**WEST SUSSEX COUNTY COUNCIL
STRATEGIC PLANNING CONSULTATION**

SUBJECT: R/305/14/PL - Erection of 1 No 3 bed dwelling & 1 No 4 bed dwelling & demolition of existing garage & shed & erection of new car port. This application affects the character & appearance of the Rustington Conservation Area.

Land To The South of The Tiled Barn, Station Road, East Preston, BN16 3AR

Brick Wall
Adjacent to access

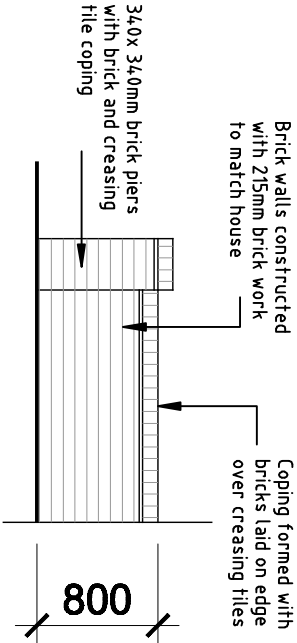
The above proposal has an existing access onto Station Road. The plans submitted indicate that the 2 new dwellings would utilise the access in its current form. No alterations are proposed to the access itself which is an acceptable width to serve both new dwellings. The plan to remove the existing high gates and fencing around the site would be seen as an improvement to Highway Safety at this location, this would increase visibility to the north east for an emerging vehicle. We would seek that the wall is built at 0.8m to ensure an emerging vehicle can see a pedestrian clearly on the adjacent footway.

CLUB/IN	
Globe Estates (Southern) Ltd	
PROJECT	
Land of The South of The Tiled Barn Station Road, Rustington	
TITLE	
Proposed Site Layout Parking Spaces Tracking	
DRAWN	DATE
T Zajac	Feb 2015
ENGINEER	CHECKED
G Walter	GW
TOLER	
1:250 @ A3

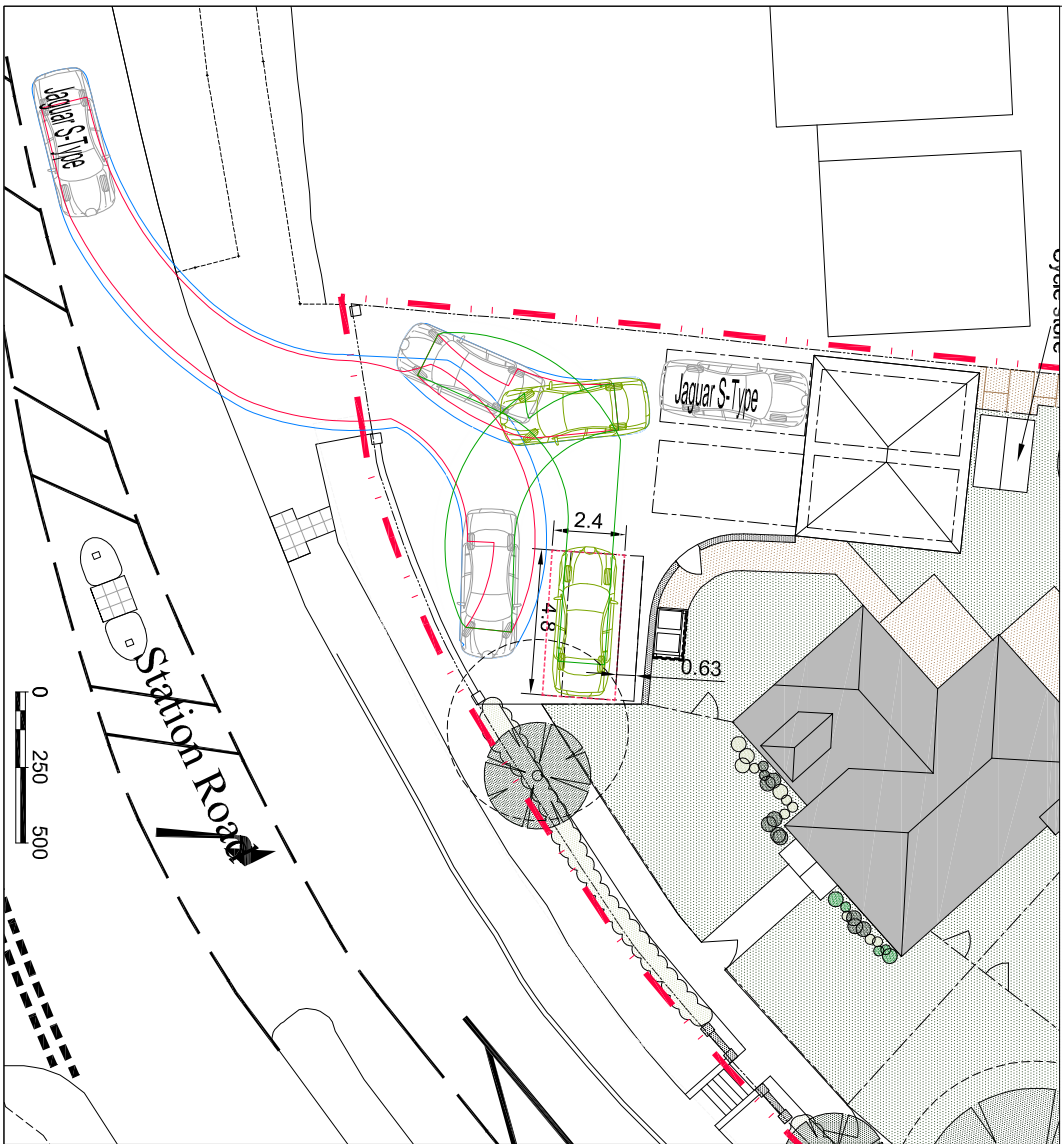
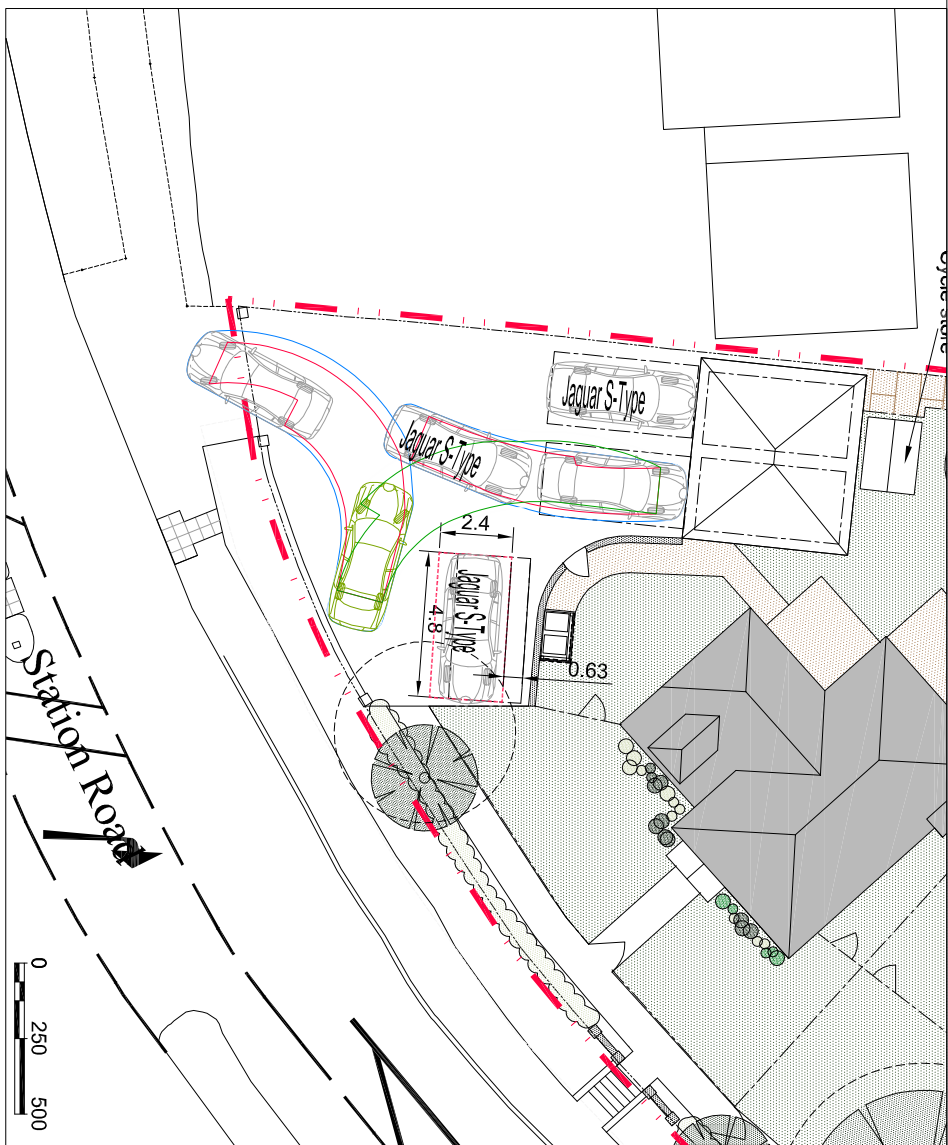
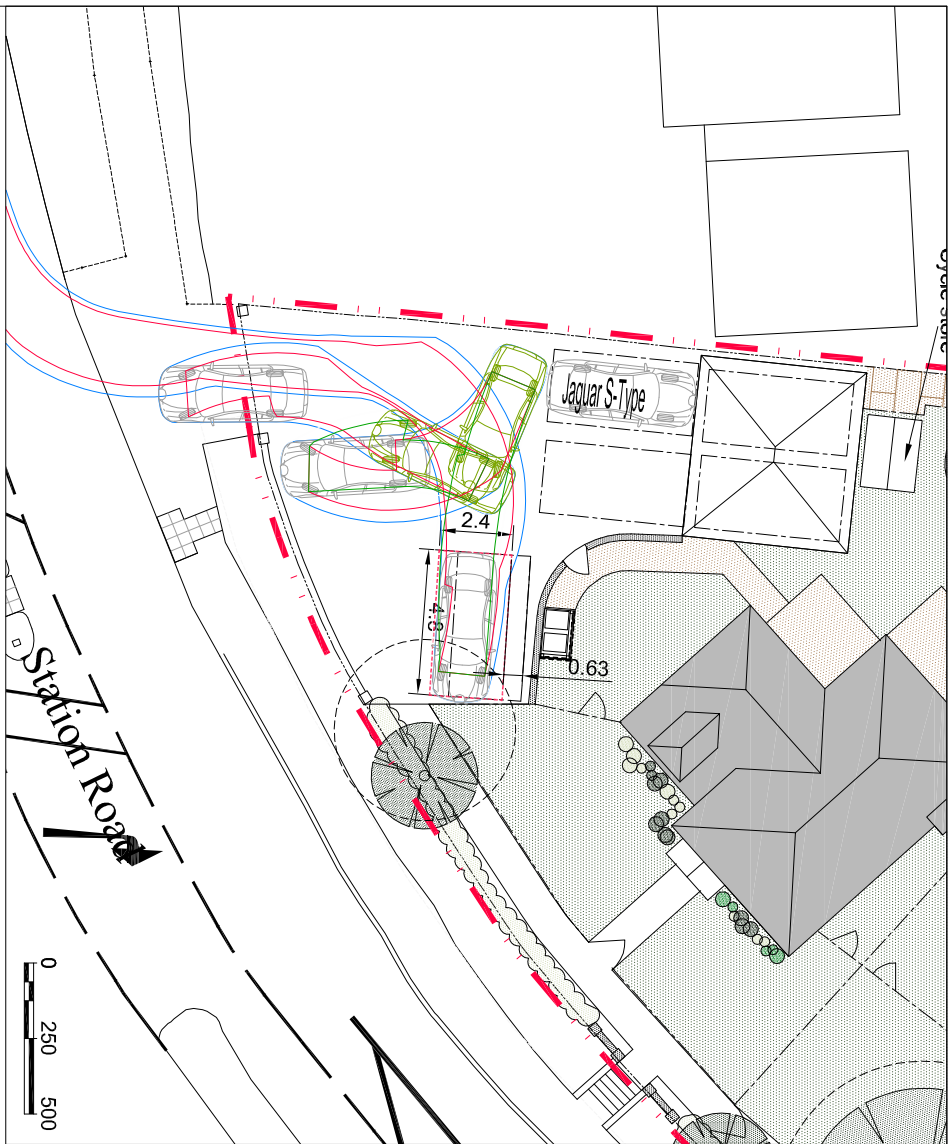
The submitted site plan does not include any detail of visibility splays from a 2.4 metre set back. Given the layout of the road in the immediate vicinity this information would be required. Please supply a plan showing the visibility that can be achieved.
